ADDITIONAL INFORMATION

APPLICATION FP/302/17/PL

Outbuilding 10 Kingsmead Felpham

Nov 2017
1-100, 1-500
DRG 1.B.

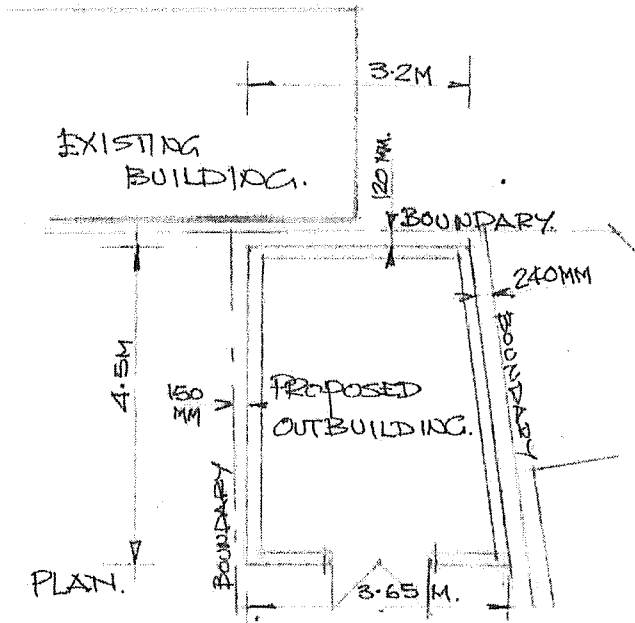
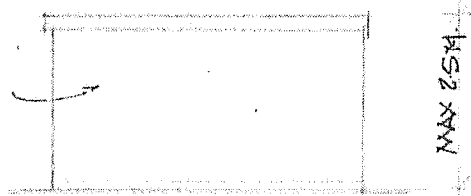
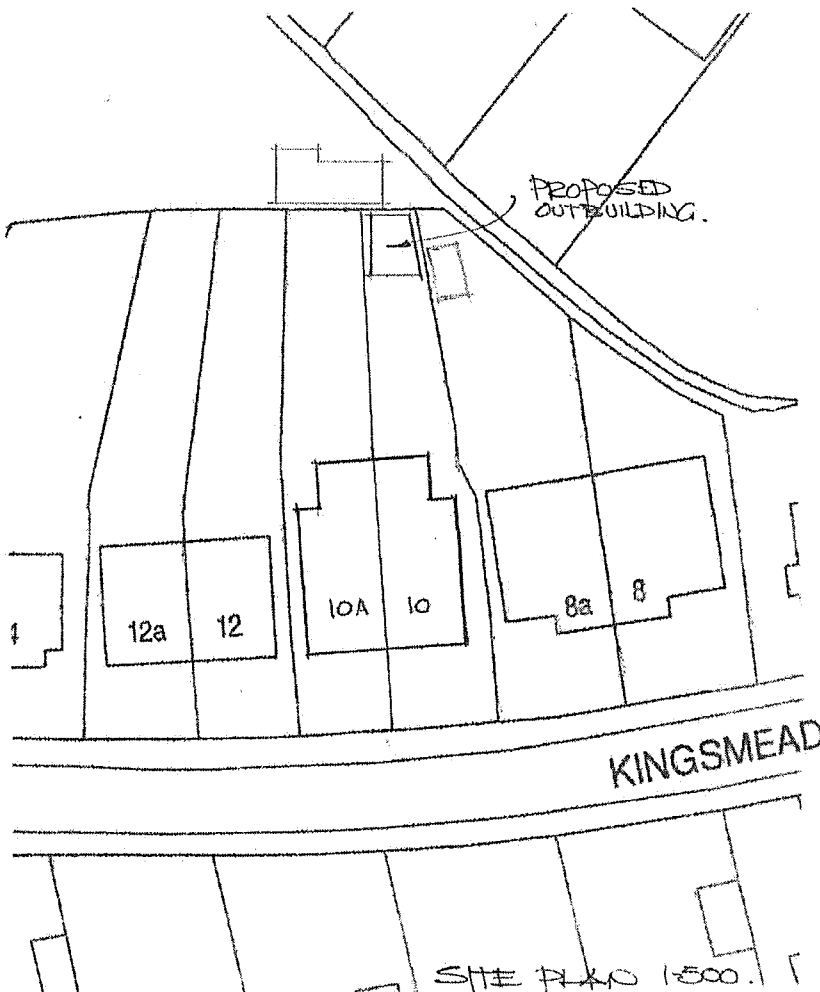
1 Application drawing

We have re-surveyed the area of the garden, following installation of new fences and the base for the outbuilding. Drawing 1B is enclosed showing;

Objection - Clarification needed as insufficient information on height and size of Outbuilding. Boundary issues as looks very 'snug' on drawings to neighbouring properties. This could create a precedent.

- The building reduced in size to reflect the base installed
- Plan dimensions added (maximum height of 2.5m already indicated)
- Existing outbuilding in the rear garden of 8A added

The proposed outbuilding is located at the northern end of the garden, furthest away from the dwelling (13m) and adjacent dwellings. Dimensions to adjacent dwellings are;

- 8A Kingsmead 16m
- 10A Kingsmead 13m (second new house of the development)
- 12 Kingsmead 20m
- Properties in Links Avenue 20m minimum
